Application Reference: 2026/0078

Site Address: 18 Canada Street, Worsbrough Common, Barnsley, S70 4JZ

Introduction: Erection of two storey outbuilding comprising of garage, sun-lounge, gym and storage.

18 CANADA STREET, S70 4JZ

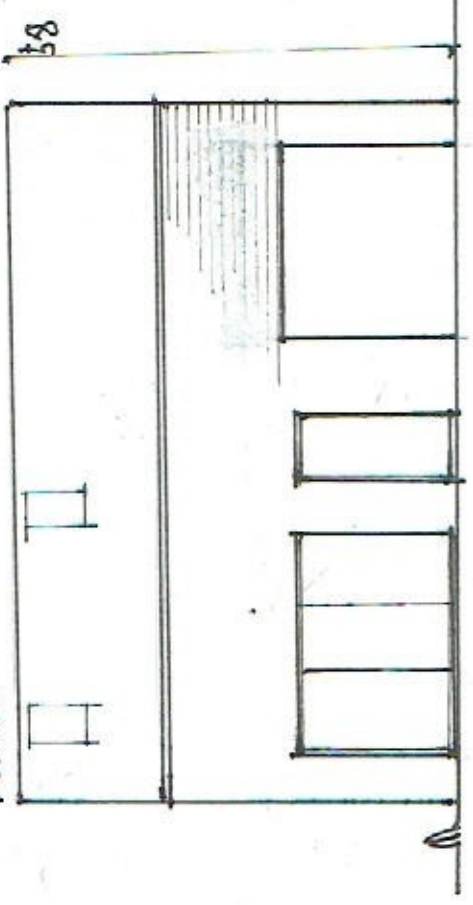
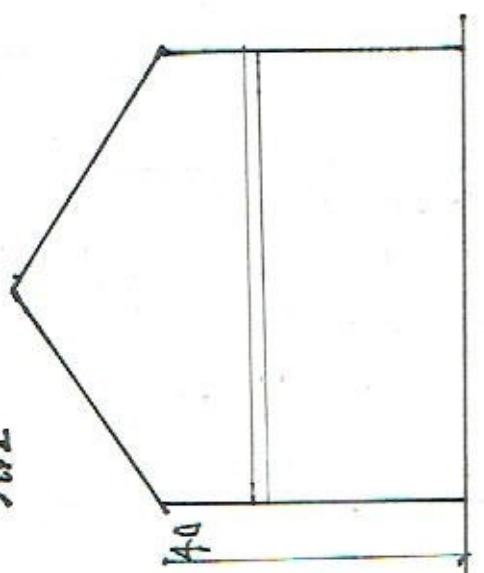
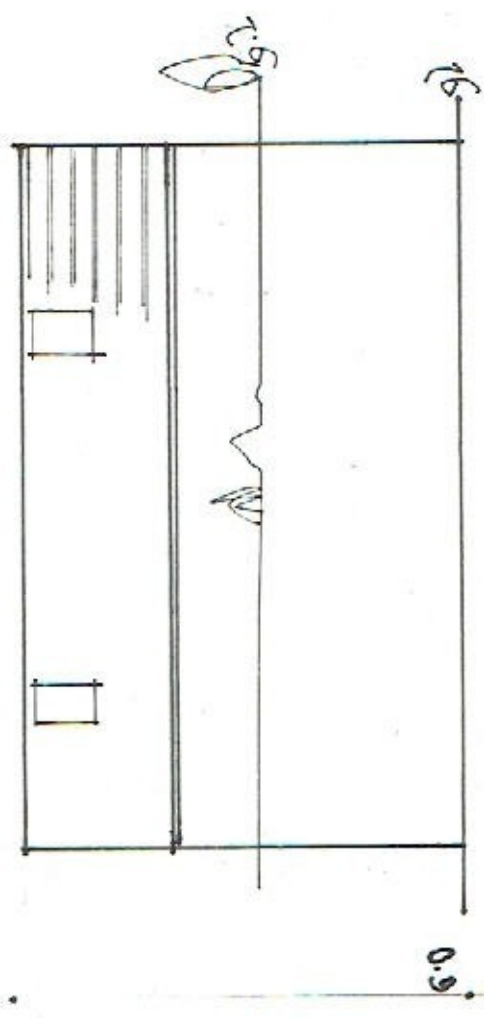
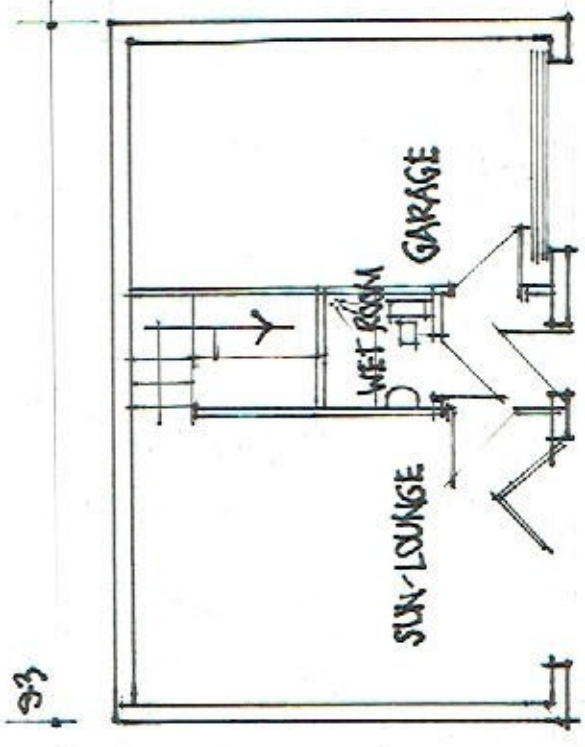
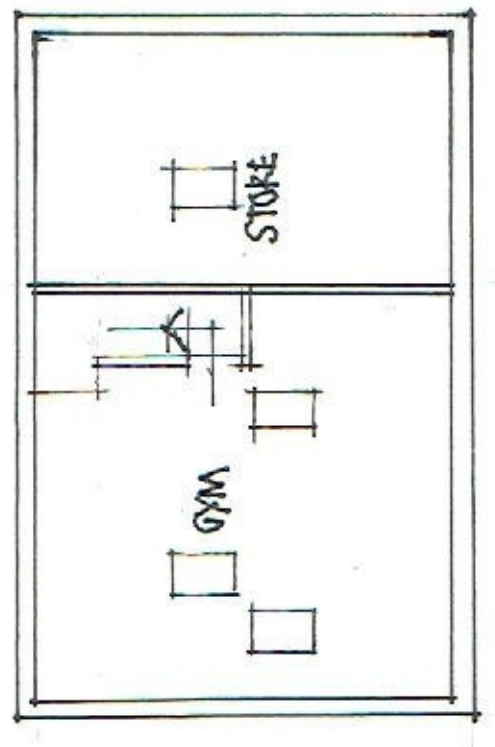
Although the proposal may not exceed the height of the neighbouring garage to the east of the site, this would be achieved by the excavations which have already taken place, and which have lowered and levelled the ground level considerably. The House Extensions SPD clearly outlines outbuildings and garages should be single storey structures. A two-storey proposal would therefore be contrary to local policy and would not be acceptable and has the potential to set a poor precedent for excavating sites to allow for garages and outbuilding which may be less impactful on neighbours but are still contrary to planning policy. The proposal also details an eaves height of 4 metres, exceeding the permitted eaves height set out in the House Extensions SPD by 1.5 metres. The proposal details a ridge height of almost 6 metres, exceeding the permitted ridge height set out in the House Extensions SPD by 2 metres.

The proposal details an approximate floor space of 96.8 square metres. Although the House Extensions SPD does not specifically outline the maximum floorspace for a garage or outbuilding, it is generally considered the floorspace should not exceed the 39 square metres outlined for an annexe in the House Extensions SPD. Even if some leniency was given to allow a slightly larger proposal than what is usually acceptable, a floorspace of 96.8

square metres is almost 250% larger than the permitted 39 square metres and is considered substantially excessive and a significant overdevelopment of the site.

The South Yorkshire Residential Design Guide advises a 1 bed, 2 person dwelling should provide a floor area of 47 square metres and a 2 bed, 3 person dwelling should provide a floor area of 62 square metres. The proposed outbuilding would therefore provide a floor area which exceeds the requirements for a 1 bed, 2 person dwelling and therefore exceeds a size tantamount to a new 2 bedroom dwelling on the site.

It is therefore considered that the proposed outbuilding/garage is not acceptable in terms of visual amenity and does not conform Local Plan Policy D1: High Quality Design and Place Making and the adopted House extensions SPD due to its excessive height, excessive floorspace and two-storey construction and as such carries substantial weight in opposition of the application.

- 1) In the opinion of the local planning authority, the proposed outbuilding/garage exceeds the maximum 2.5 metre eaves height, 4 metre ridge height and 39 square metres floorspace outlined as acceptable within the House Extensions SPD. Consequently, this application is considered to be contrary to Local Plan Policies GD1: General Development and D1: High Quality Design and Place Making.

It has been necessary to make contact with the applicant to request plans and elevation which provide a single storey scheme in line with the House Extensions SPD with a maximum eaves' height of 2.5 metres, a maximum ridge height of 4 metres and a significantly reduced floorspace. No amendments were forthcoming and the agent outlined a request for a decision based upon the current proposal.
